Date: 03 January 2024

Cherwell District Council Ecology Officer's response to Padbury Brook Solar Farm (ref 22/03873/F) received 28th December 2023.

Further to the above response to the Padbury Brook Solar Farm planning application (planning ref 22/03873/F), please find below responses to the comments raised. This covers two key themes:

Client
JBM
Project:
Padbury
Drawing Title:
Site Layout Plan - 1 of 4
Drawing No: 1051745-ADAS-XX-XX-DR-PL-8001
Scale: 1:1000 at A1
Drawn by: A.F. Date: 26/07/22
Checked by: D.H. Date: 26/07/22

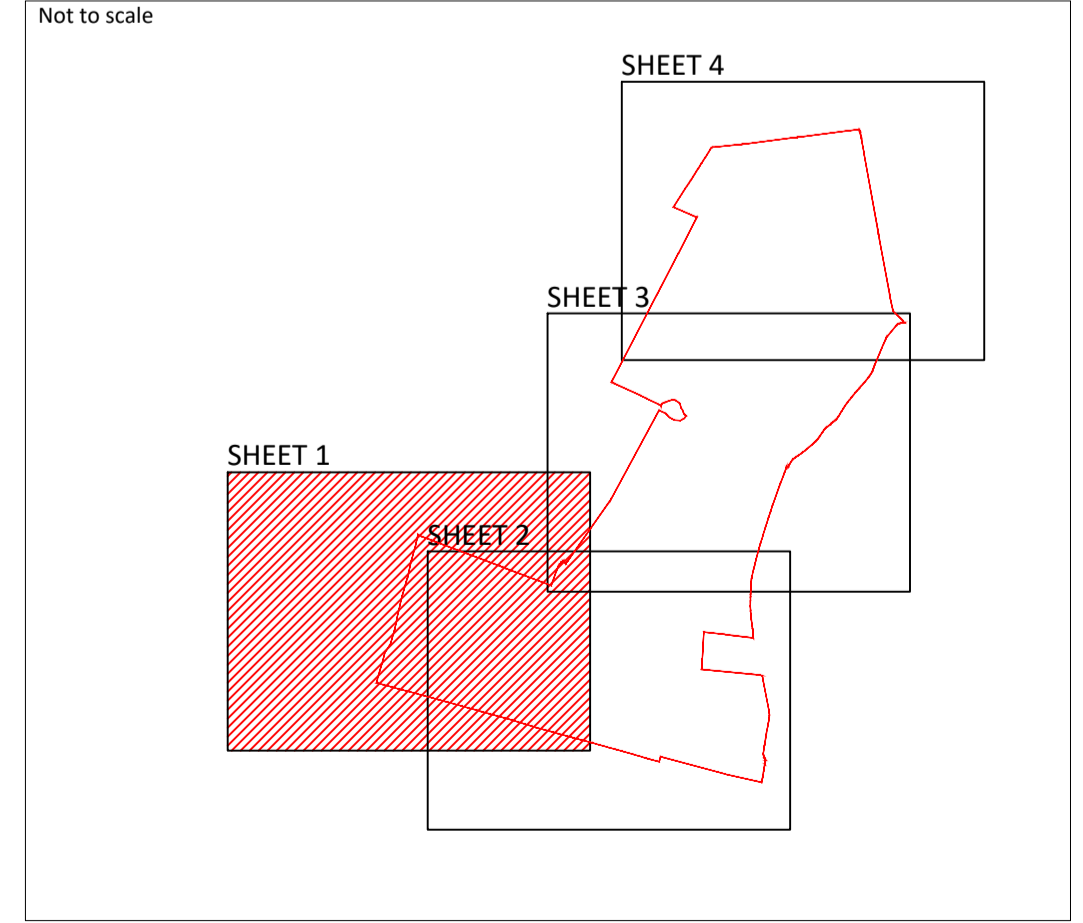
Following comments made by BBOWT over the type of grass mix to be used, we have opted to use a *Habitat Aid* grazing mix as opposed to a standard grazing mix. We welcome your comments acknowledging that a change of use from monocultural, intensively farmed arable land subject to chemical inputs, to preserved grassland would represent an improvement for local wildlife.

A 15m buffer from any development from the Oldfields Copse ancient woodland will be implemented and planted with a diverse wildflower grassland mix (EM2). This will ensure that the development is not only in line with DEFRA guidelines with regard to offsets to development from ancient woodland, but will also offer potential benefit to foraging species living within the Copse, as opposed to the current low value arable land that is adjacent. Further to this, the creation of 2.4km of new native hedgerow/tree planting across the site, including adjacent to the Copse, in addition to the loss of no trees and the protection of all RPAs on-site, will result in the increased interconnectivity of linear habitats across the site, complimenting and improving those that exist already. There will be no
